Recommendation Report for Planning Permission for Works or Extension to a Dwelling**REF NO:** EP/95/14/HH**LOCATION:** 91 North Lane
East Preston**PROPOSAL:** Demolition of existing garage (front), side entrance & toilet (single storey) & rear conservatory. New single storey garage & front porch. Single storey extension to west elevation & single & double storey rear extension. Resubmission of EP/144/13/**SITE AND SURROUNDINGS**

This application seeks planning permission for a two storey rear extension and single storey side extension on the property, a portion of which will extend to the front and will be the only change to

2001-1	PL0107	A
--------	--------	---

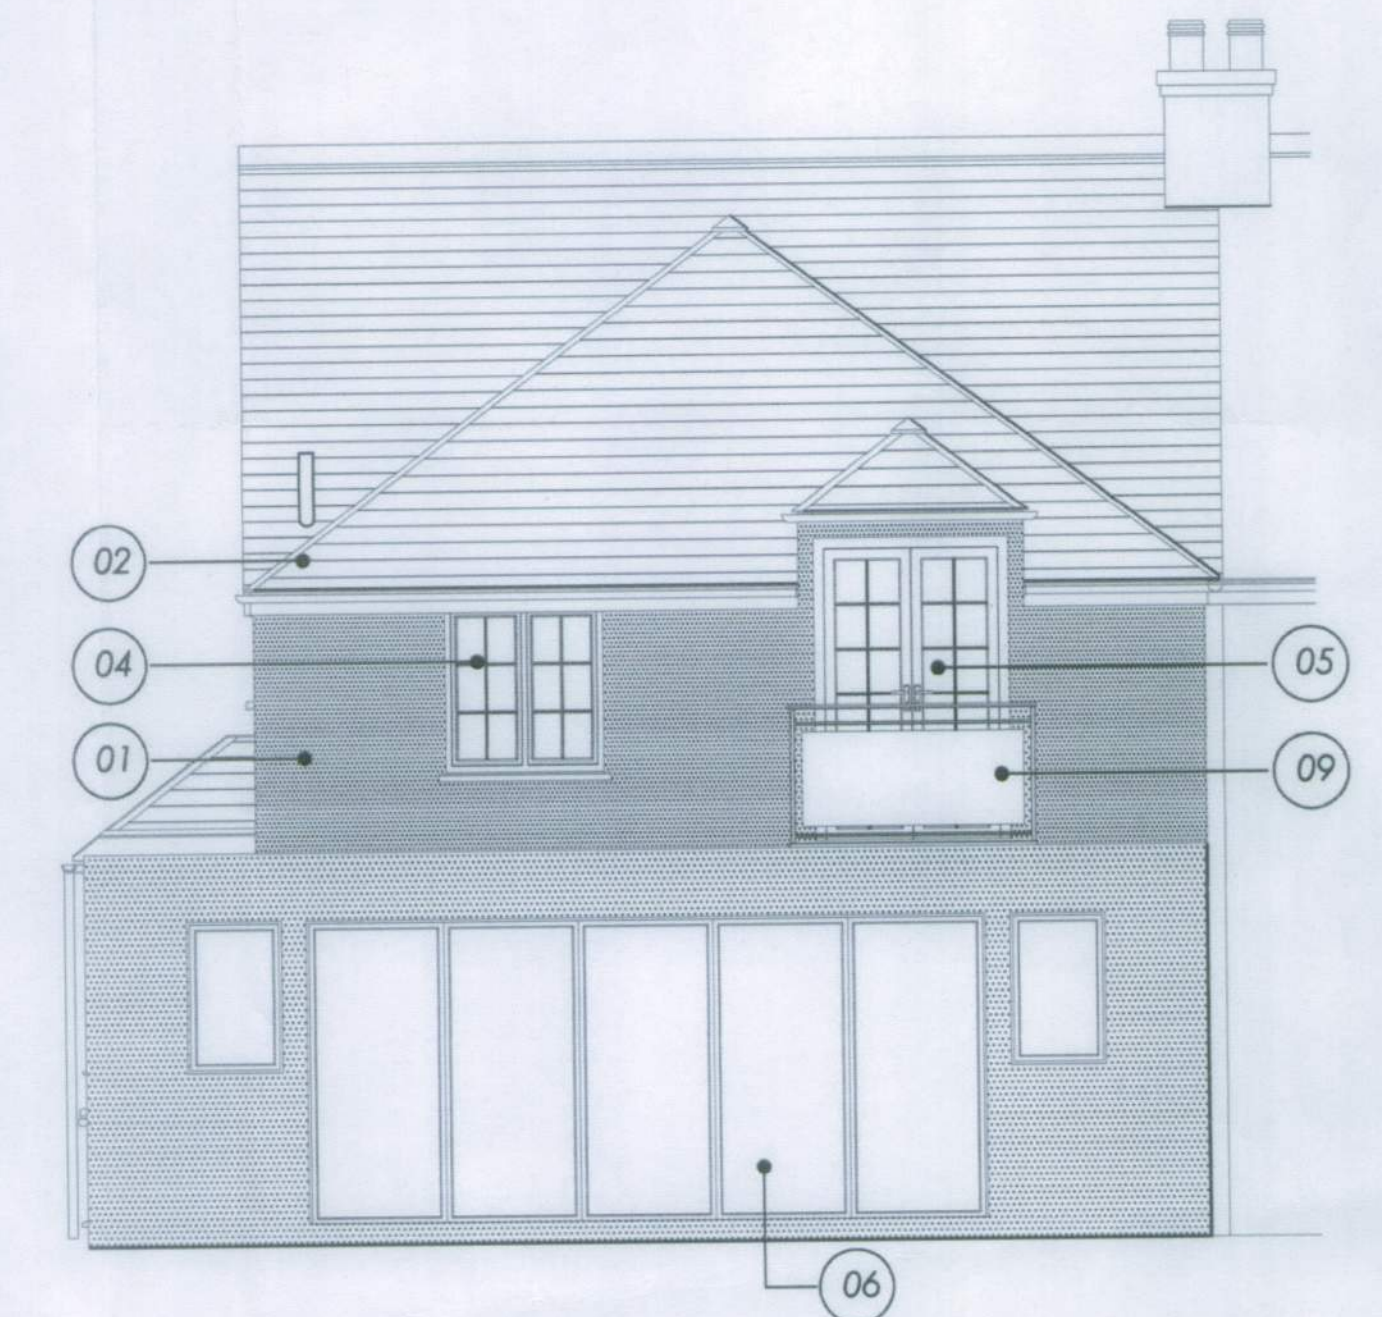
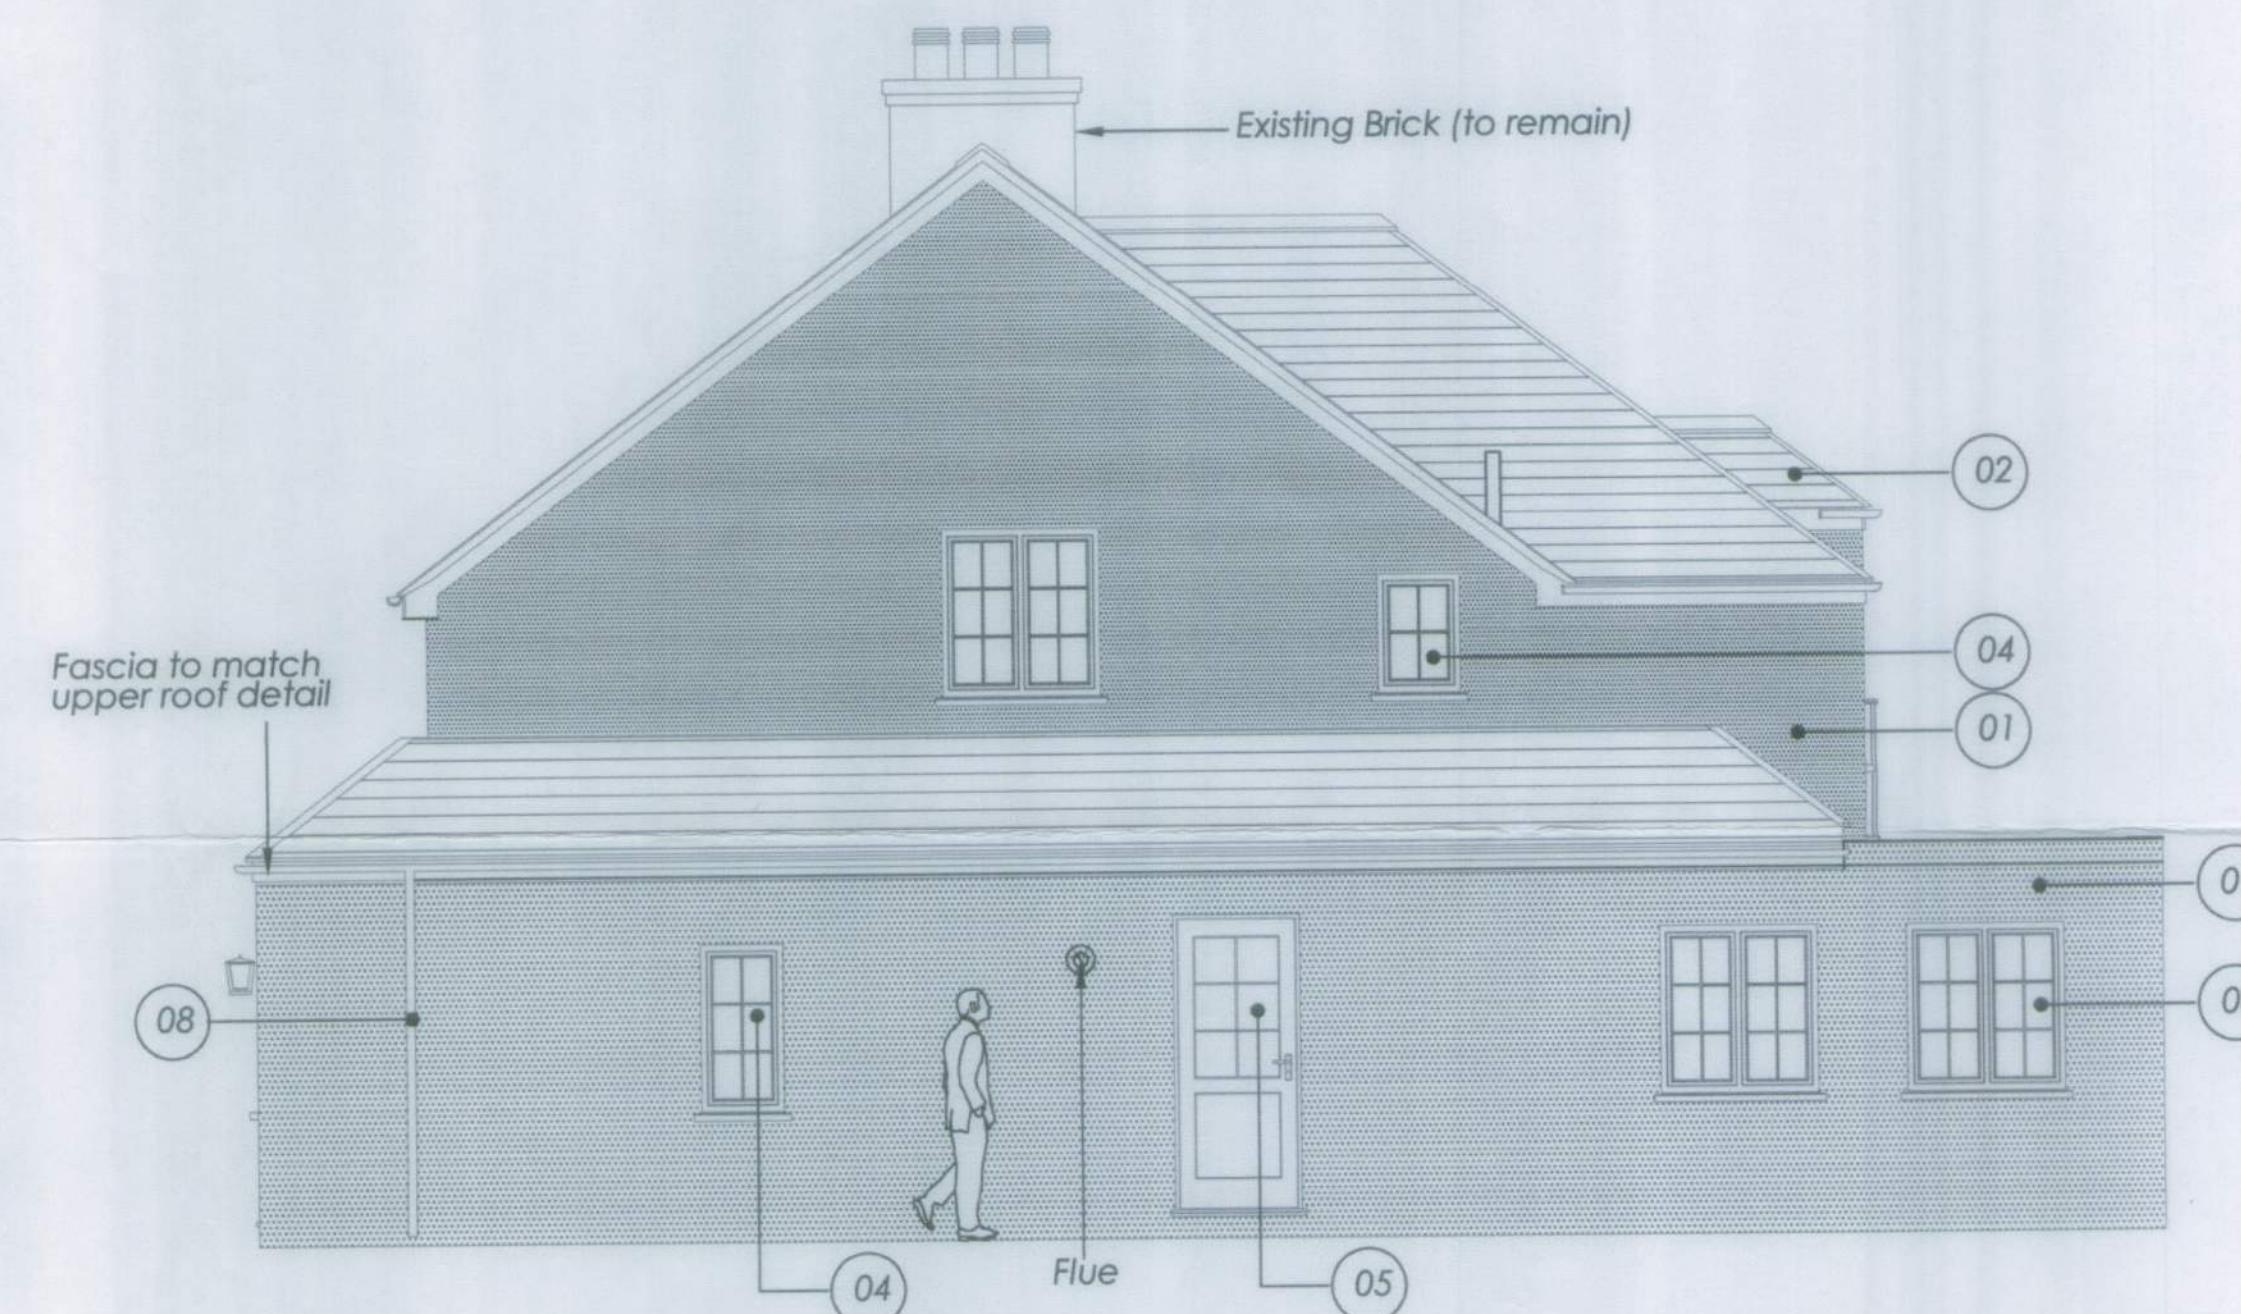
In terms of the neighbouring property of no. 93 to the west, the two storey rear extension will be acceptably distanced away to alleviate any harmful overbearing effects. A pair of windows at first floor level in the side (west) elevation will substitute a single window in broadly in the same location and as such will not cause harmful overlooking over and above existing levels. A smaller window is also proposed at first floor level in this side elevation but has been annotated on the

plans as being obscured glazed. However, it is proposed that a condition be imposed to ensure that this window is obscured glazed and fixed shut and shall remain so in perpetuity to protect the amenities of no. 93. Other windows being proposed will be at ground floor level where they will be largely screened by the close boarded fencing at approximately 1.8m in height forming the boundary treatment between the property and no. 93.

- 4 The smaller window on the side (west) elevation of the property at first floor level shall at all times be glazed with obscured glass and fixed to be permanently non-opening and shall be retained thereafter.
